WEST SUSSEX COUNTY COUNCIL CONSULTATION

TO:	Arun District Council FAO: Myer
FROM:	WSCC - Highways Authority
DATE:	21 September 2021
LOCATION:	Land to rear of Highground House & Orchard End, Highground Lane Barnham
SUBJECT:	BN/114/21/PL Creation of 1 No. 1.5 storey dwelling on brownfield (previous use commercial car parking / children's play area associated with holiday let business) (resubmission following BN/53/21/PL). This application is a Departure from the Development Plan & is in CIL Zone 3 & is CIL Liable as new dwelling.
DATE OF SITE VISIT:	n/a
RECOMMENDATION:	Advice
S106 CONTRIBUTION TOTAL:	n/a

Proposed Plans and Elevations

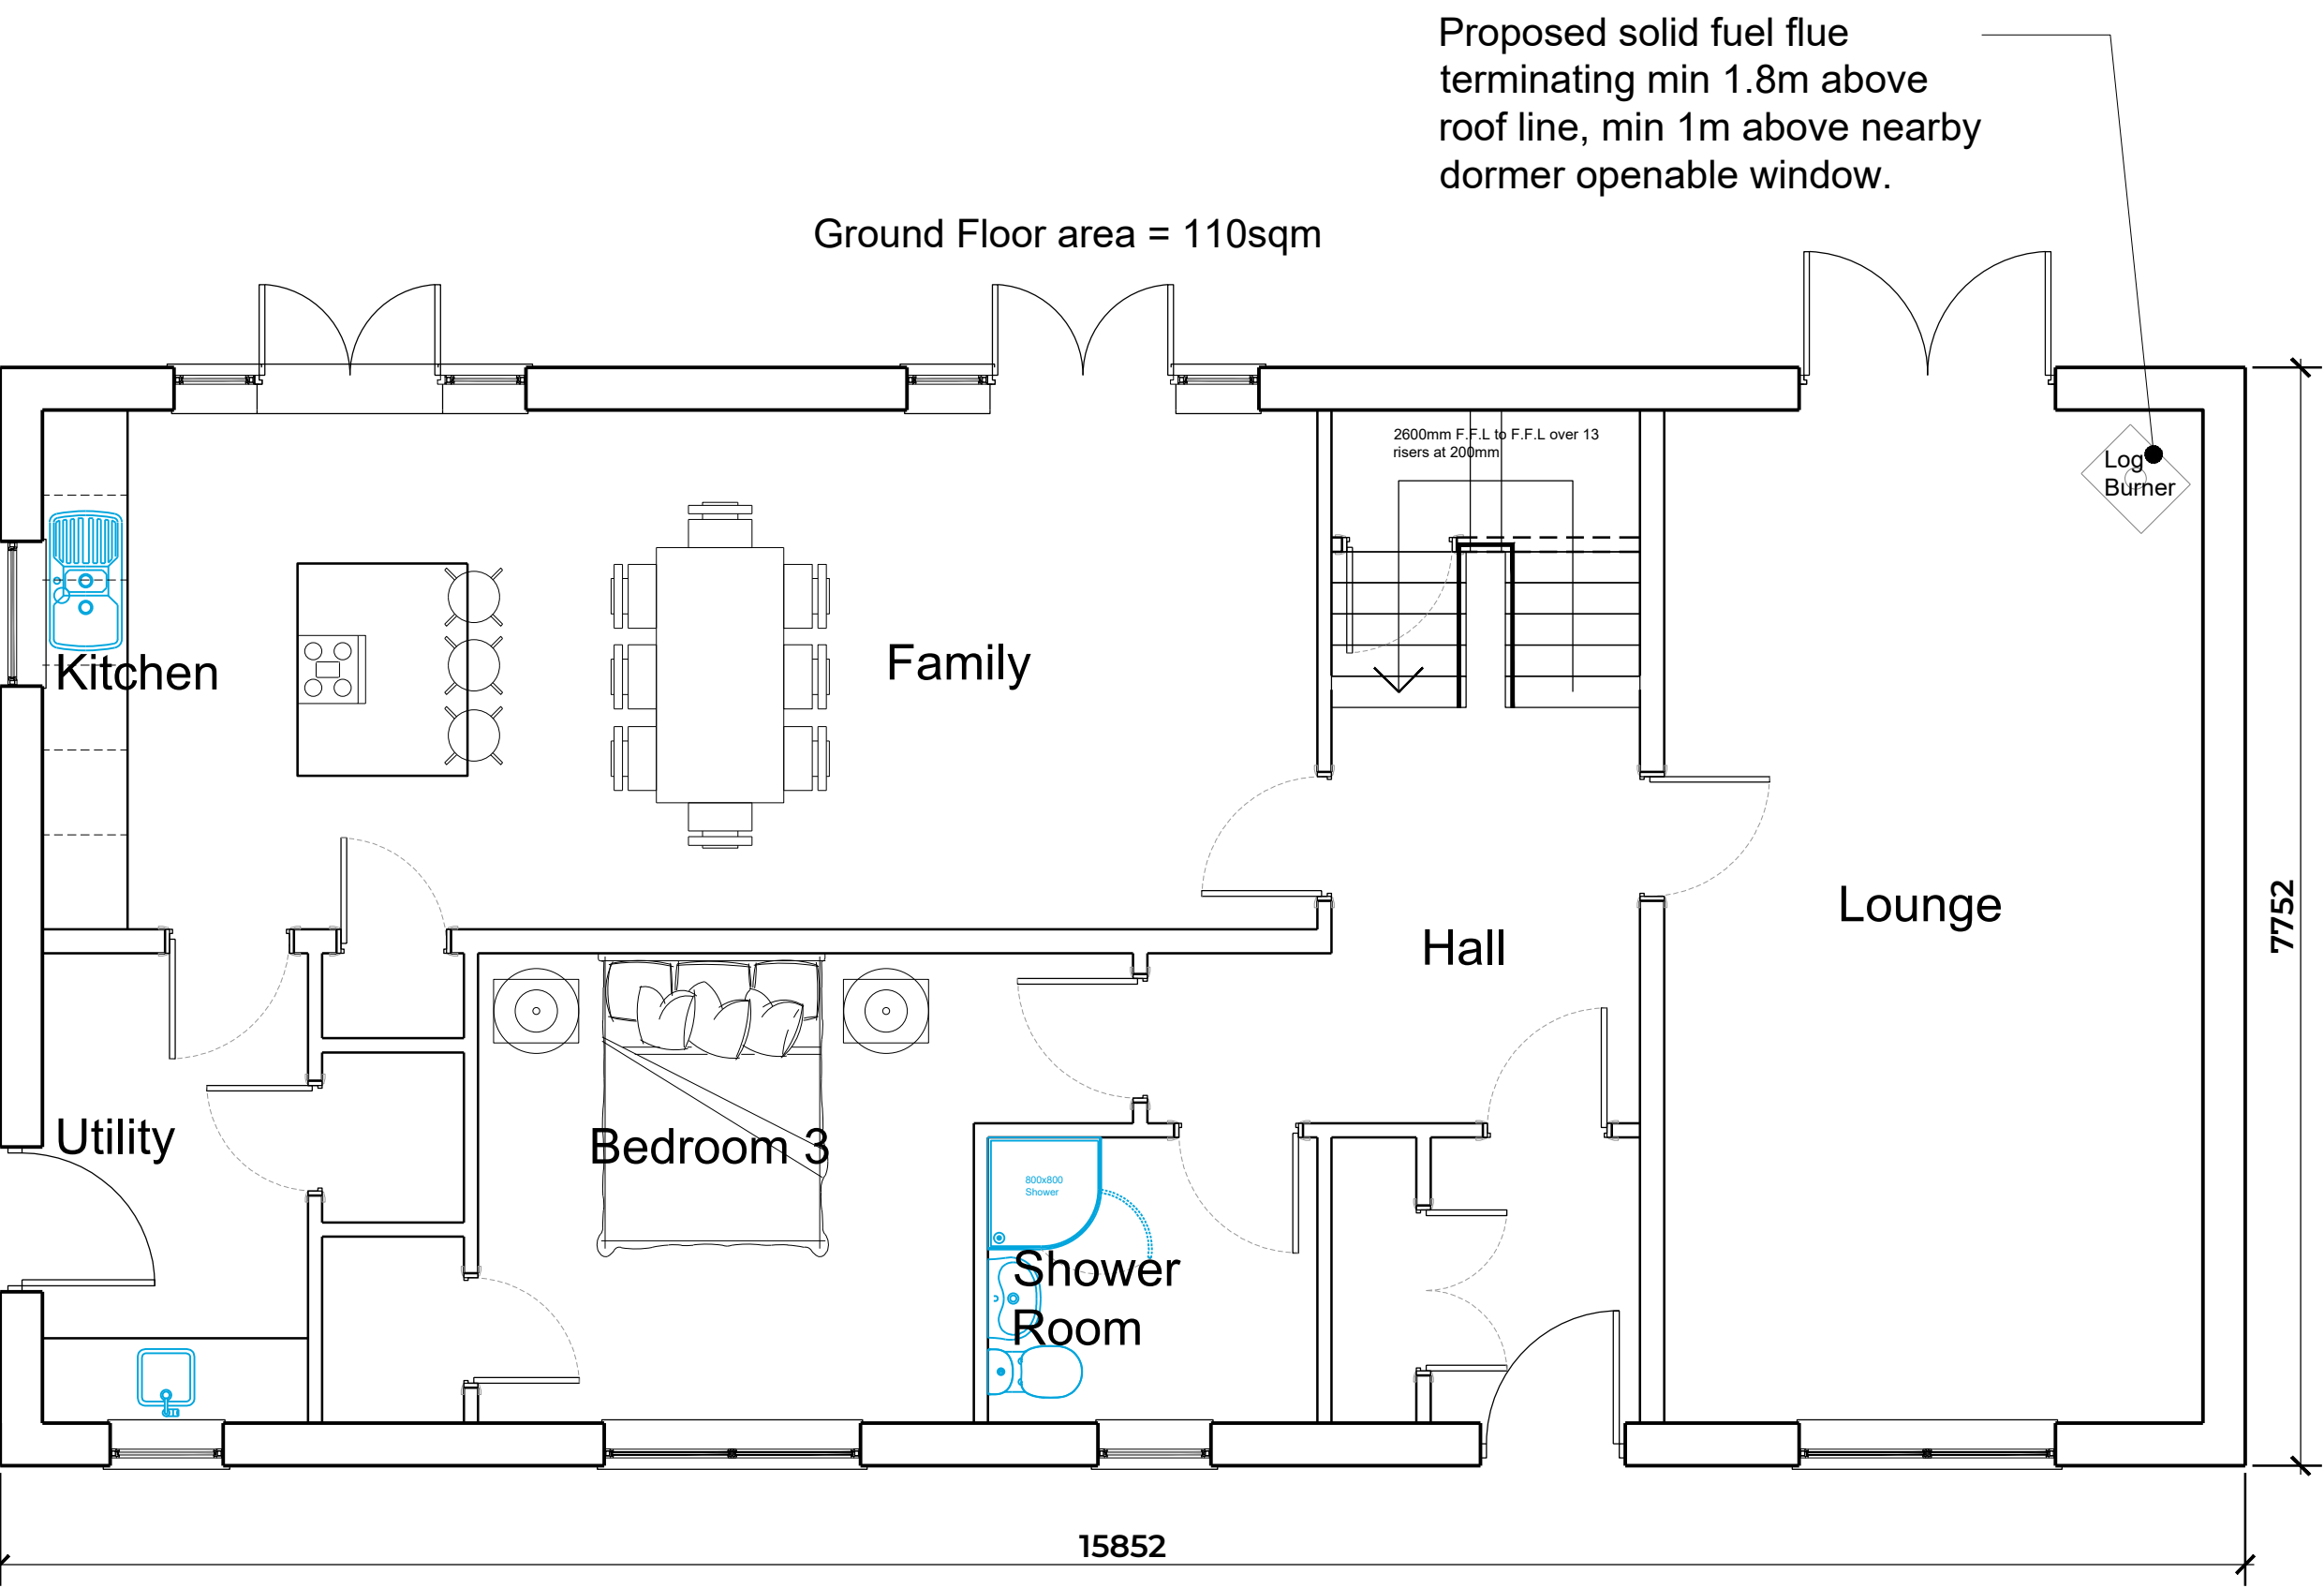
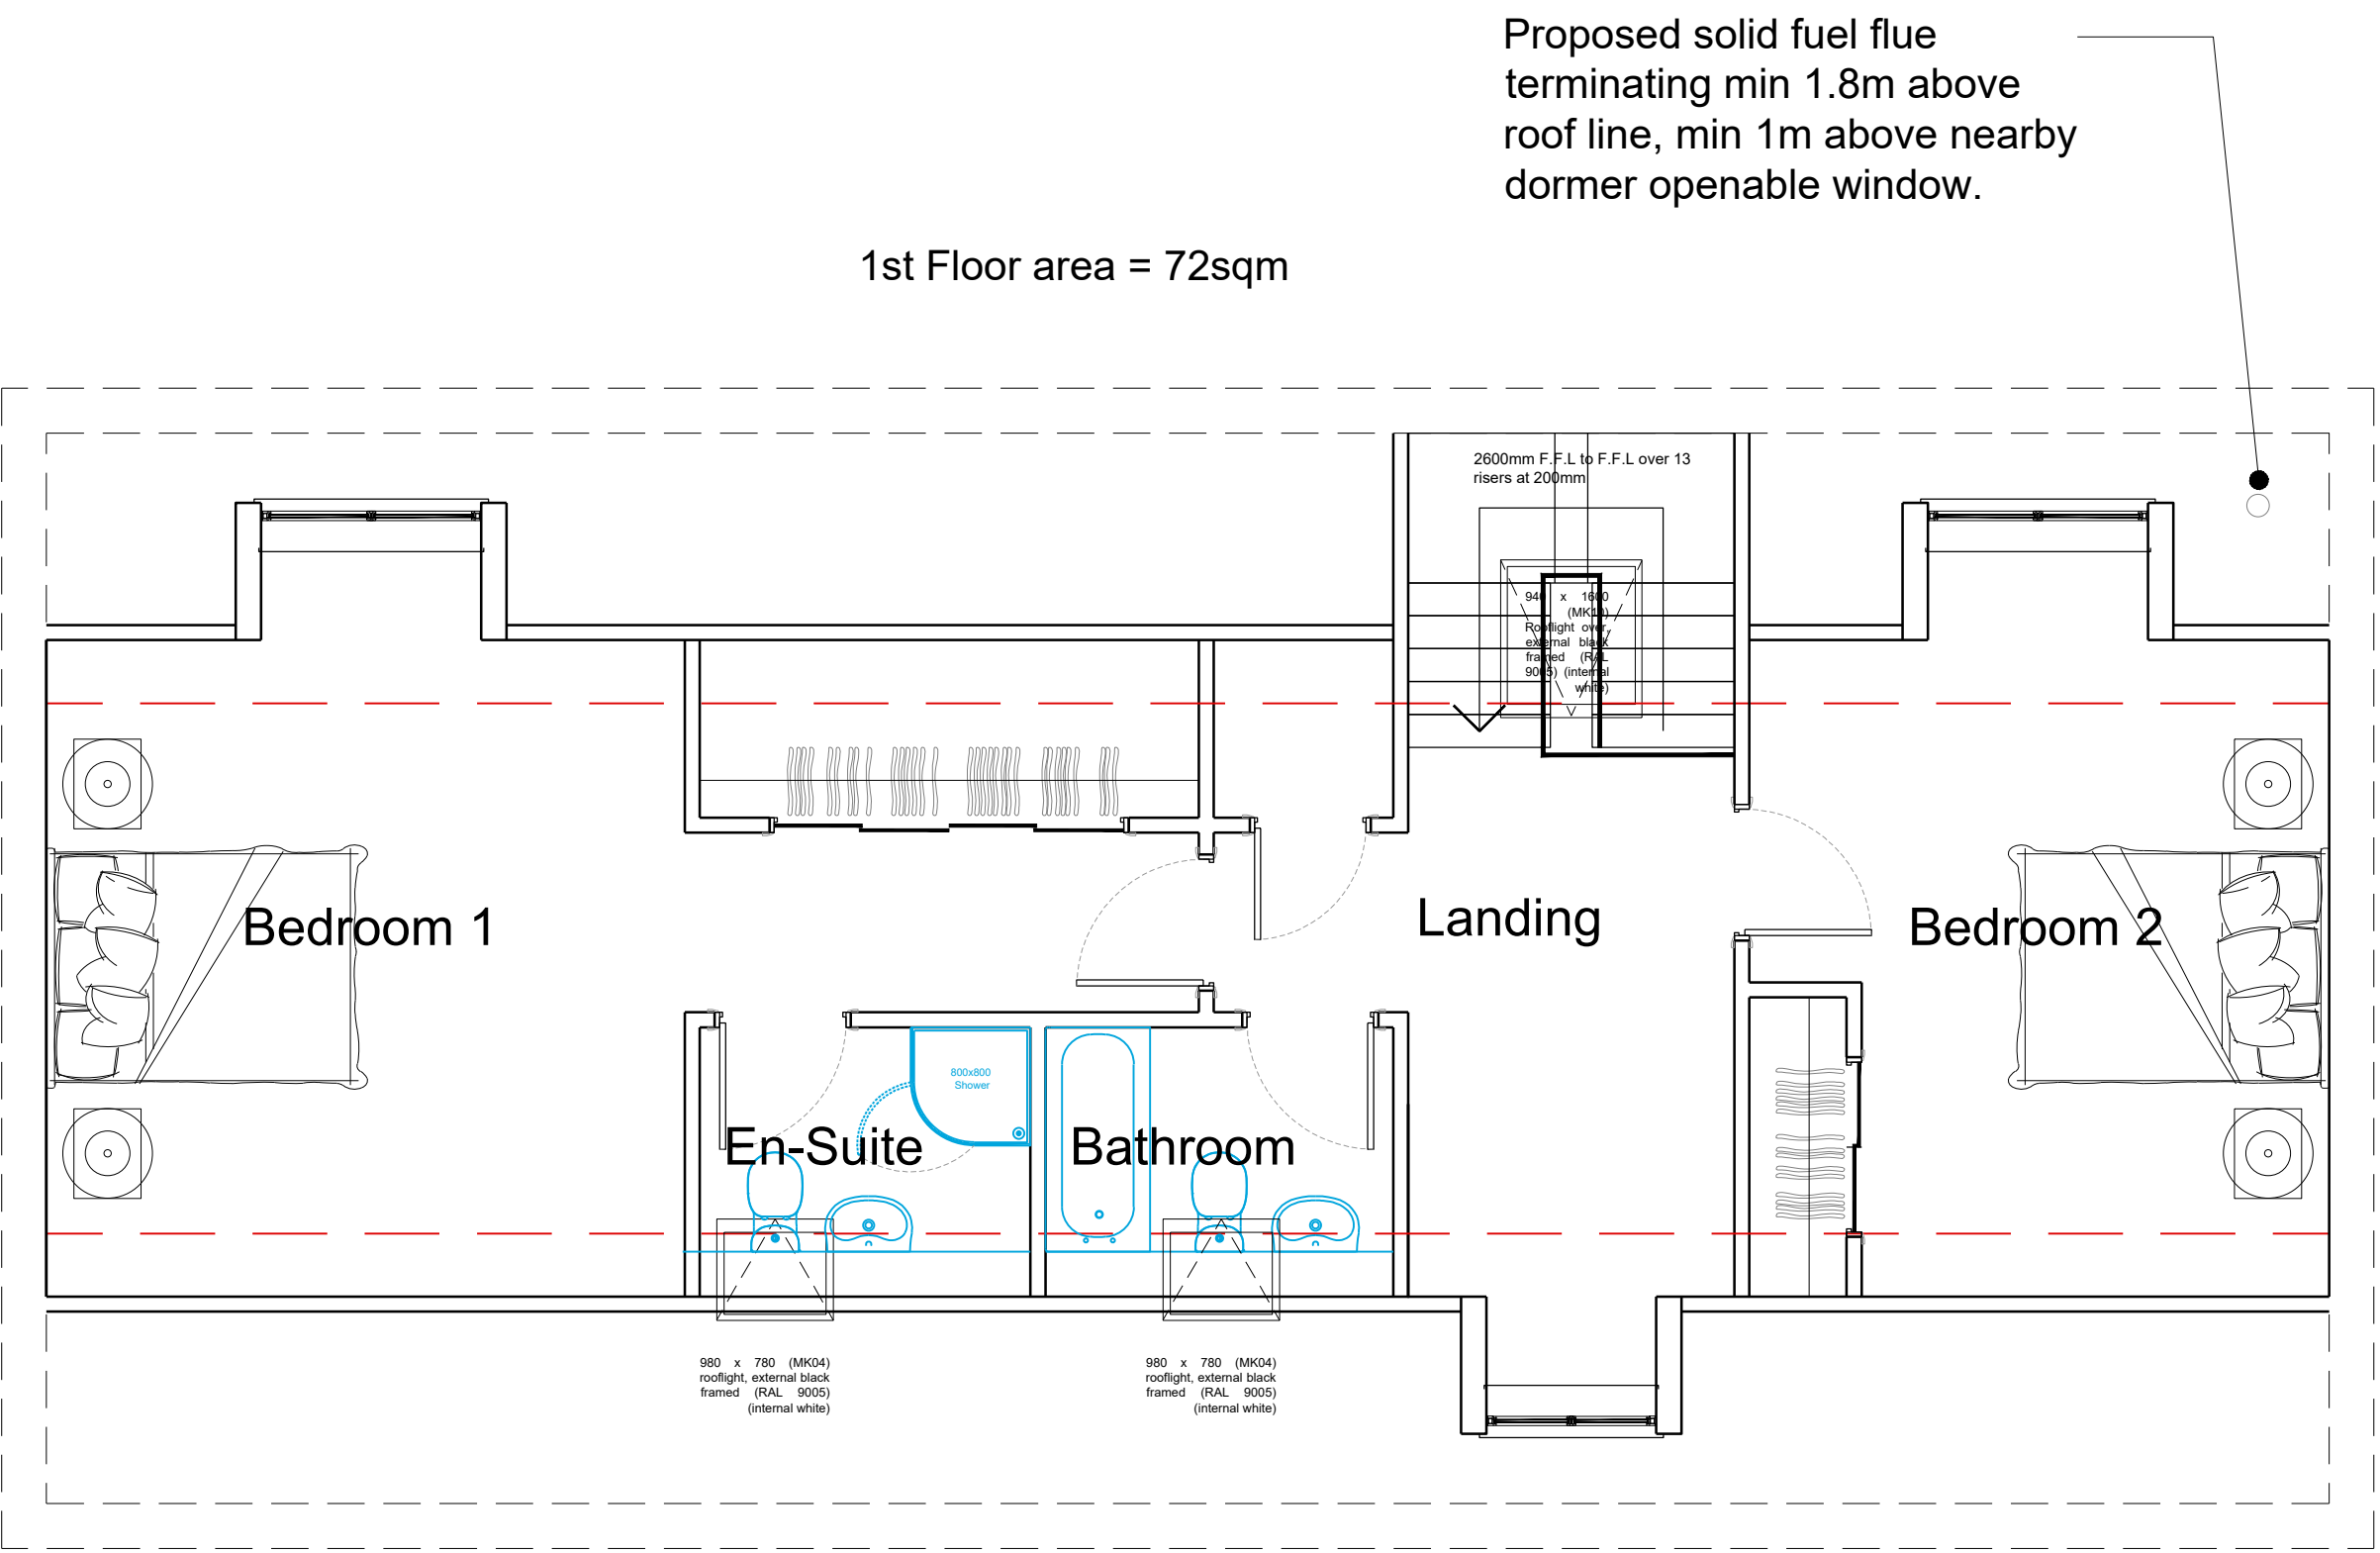
The applicant proposes a NIL parking provision for the new 3-bedroom dwelling. However, the LHA are mindful that a hardstanding area is present, large enough to accommodate such a provision on site.

The applicant has proposed a NIL cycle parking provision, the LHA advises the Local Planning Authority (LPA) that if they deem cycle parking justifiable then the applicant should show this in the form of lockable covered storage. Details of which can be secured with a suitably worded condition found below.

No part of the development shall be first occupied until the car parking has been constructed in accordance with the approved site plan. These spaces shall always thereafter be kept for their designated purpose.

No part of the development shall be first occupied until covered and secure cycle parking spaces have been provided in accordance with plans and details **to be** submitted to and approved by the Local Planning Authority.
